From: diana@pugetsoundpublishing.com
To: [Robin Proebsting](#)
Subject: questions about MICA project at Mercerdale
Date: Monday, January 30, 2017 11:46:39 AM
Attachments: [170130 MercerdalePark001.pdf](#)
[170130 MercerdalePark002.pdf](#)

I've attached the diagram and talking points I referred to in our conversation this morning. My specific concerns so far relate to the proposed draining/stormwater retention areas and the fire lane.

SHEET NUMBER
C301

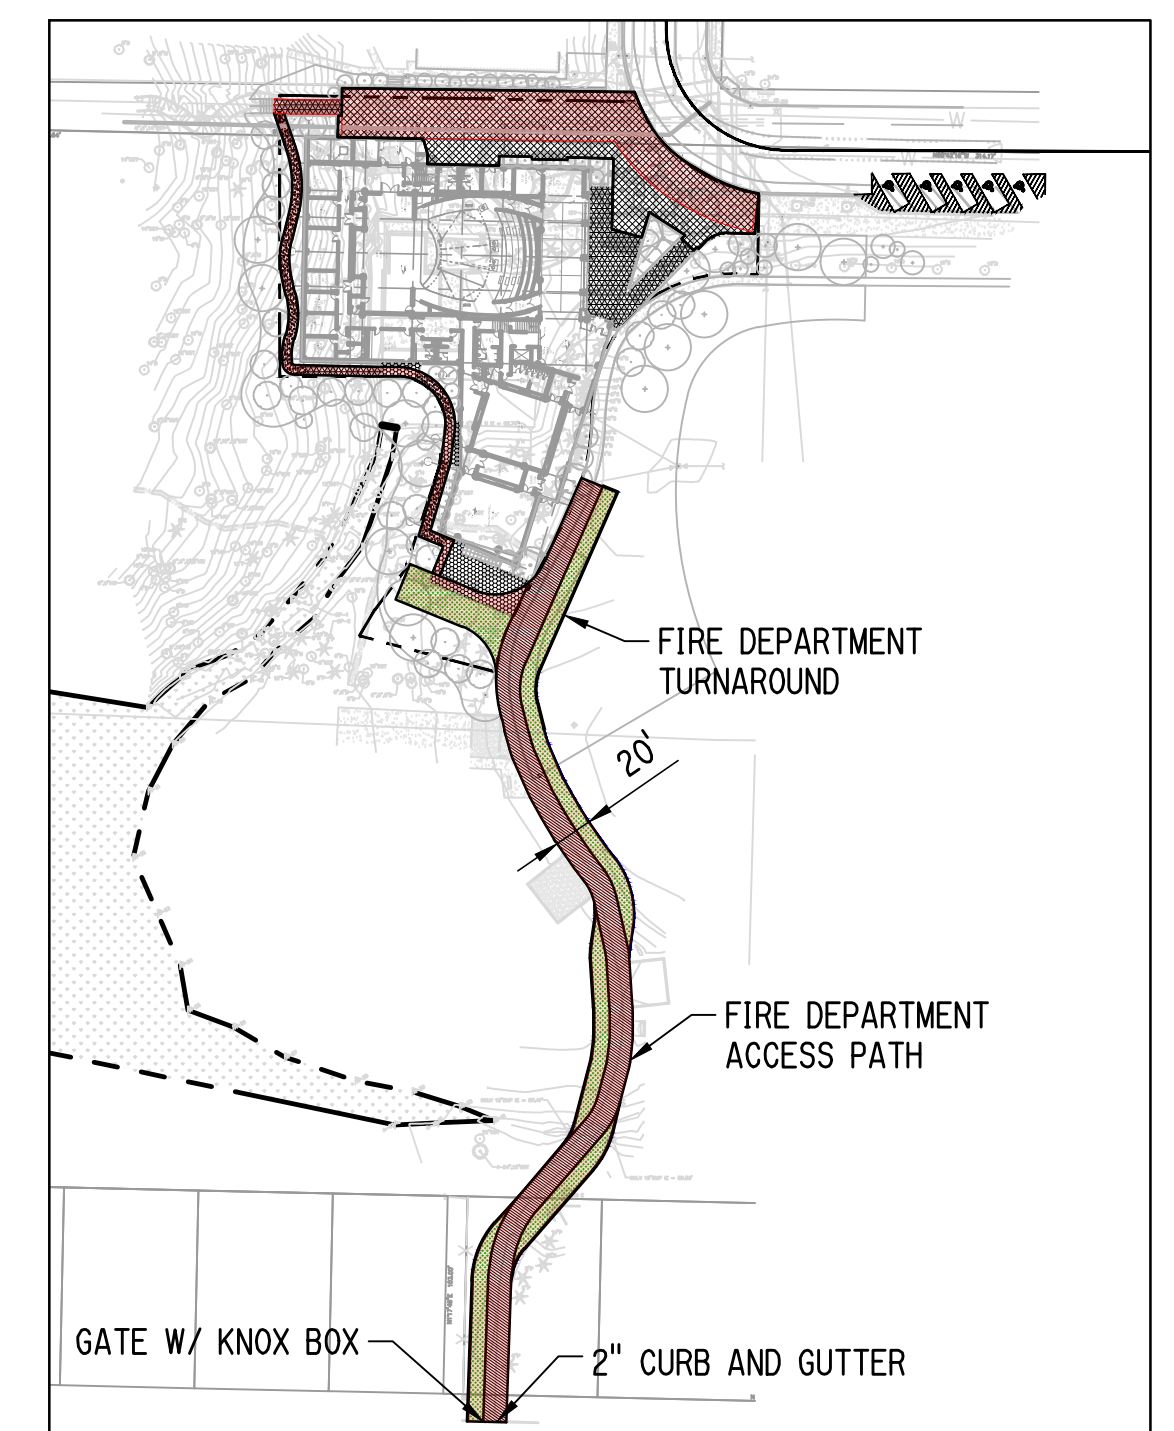
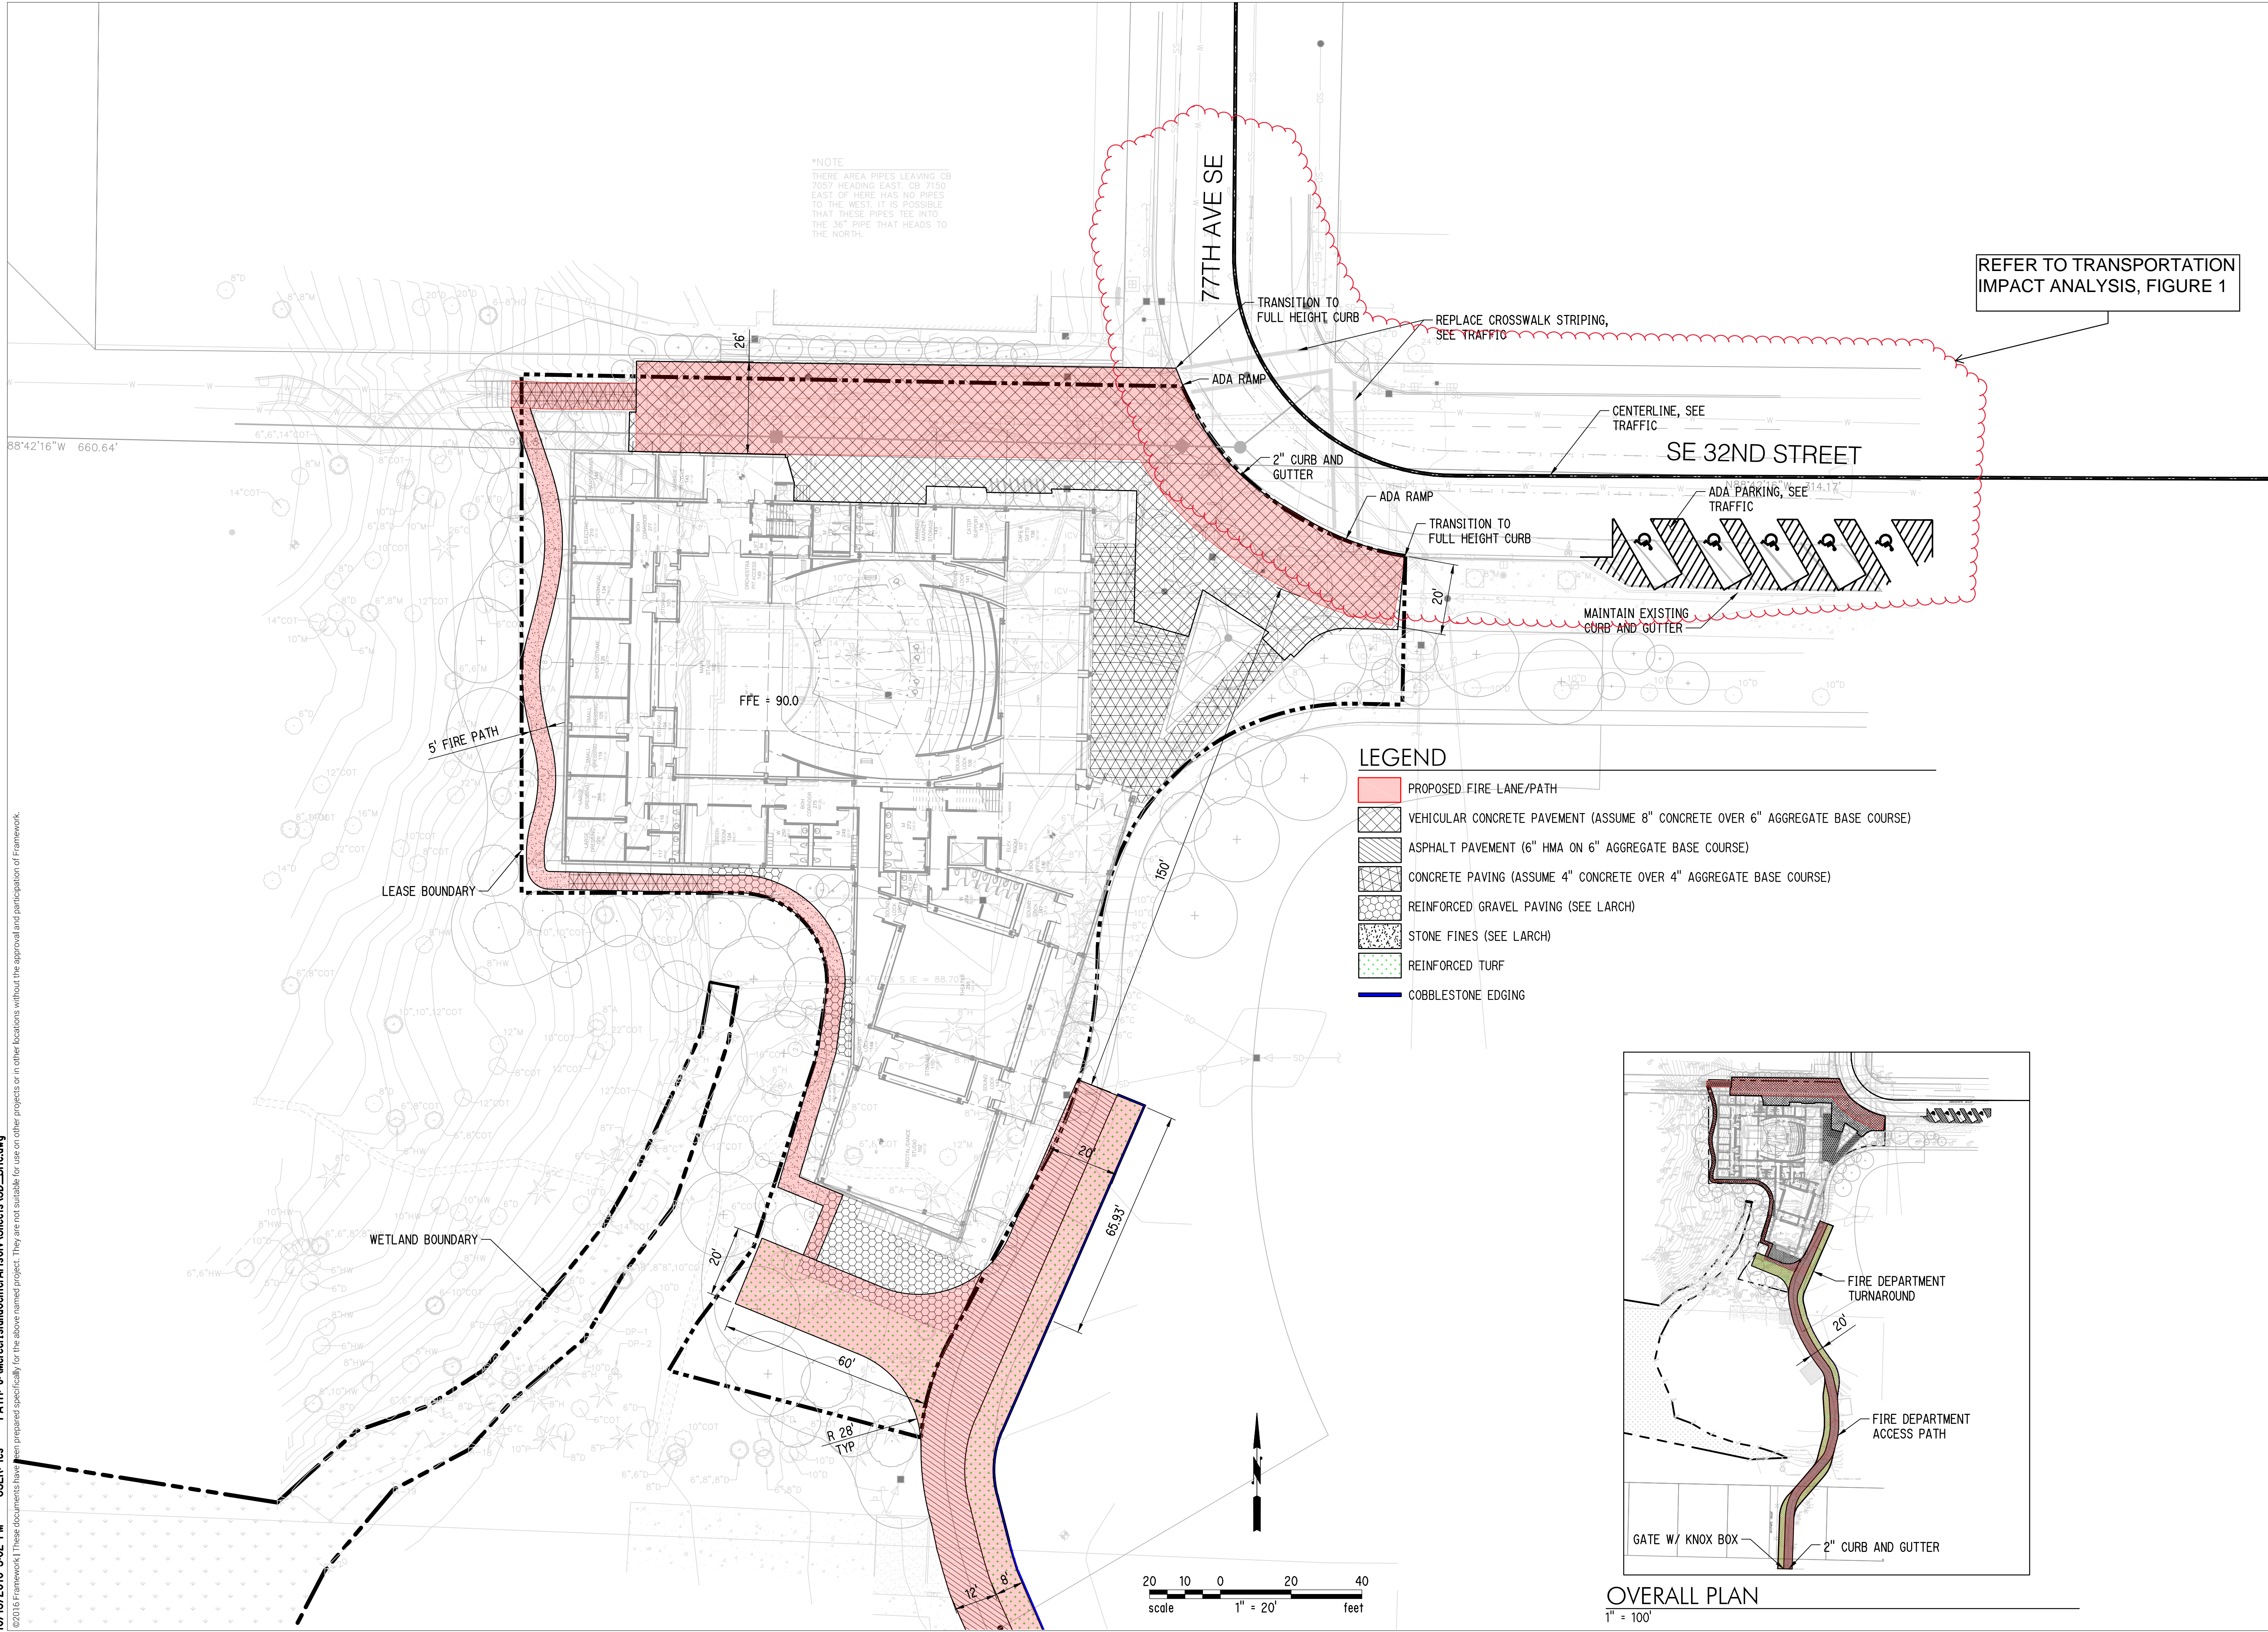
Is the underground vault really going to be 5'x5' and 4 feet high? And the retention pond 100'x20'?

And regarding the fire lane, why not just go on through the park and exit the other end adjacent to the fire hydrants (near Farmers Insurance building), rather than proposing a turnaround?
